**From:** Greg Field <gfield@lakemac.nsw.gov.au>  
**Sent:** Tuesday, 21 November 2017 5:04 PM  
**To:** Michelle Niles  
**Subject:** RE: Catherine Hill Bay (MP 10\_0204 MOD 6) - Response to Submissions

I have reviewed the report prepared by ADW Johnson in response to Council's submission. Council's comments on the three points are provided below.

**From:** Michelle Niles [mailto:Michelle.Niles@planning.nsw.gov.au]  
**Sent:** Tuesday, 21 November 2017 2:06 PM  
**To:** Greg Field  
**Subject:** Catherine Hill Bay (MP 10\_0204 MOD 6) - Response to Submissions

Figure 1: Indicative Stage 7 Stormwater Layout

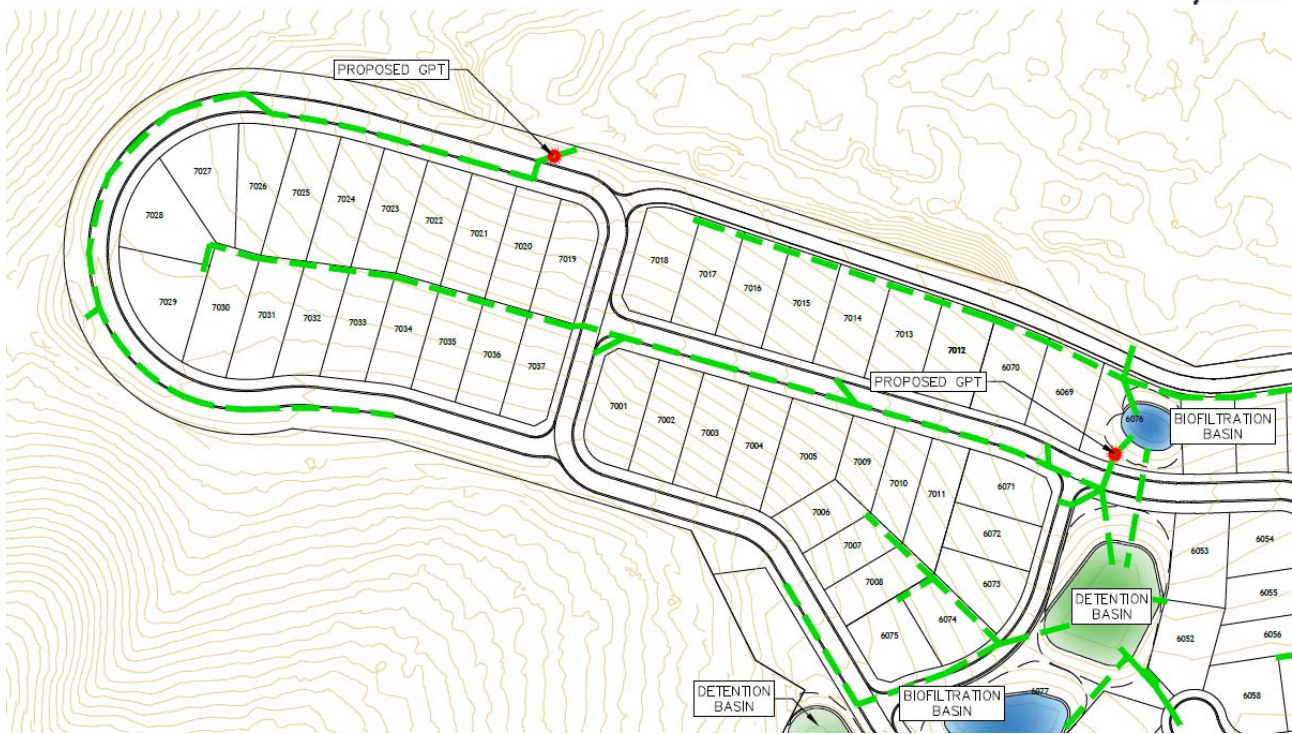
2. Council believes that the stormwater management for this development site does not meet the standards specified in Council's Engineering Guidelines. However, the stormwater design for Stages 6 and 7 is consistent with the designs approved by the Department for the rest of the estate. The lack of adequate stormwater detention and water quality controls will impact on the downstream landowner, being the National Parks and Wildlife Service. Council recommends that you consult with the NPWS concerning the stormwater design and if NPWS do not have any issues with the design then Council would not oppose the outcome.
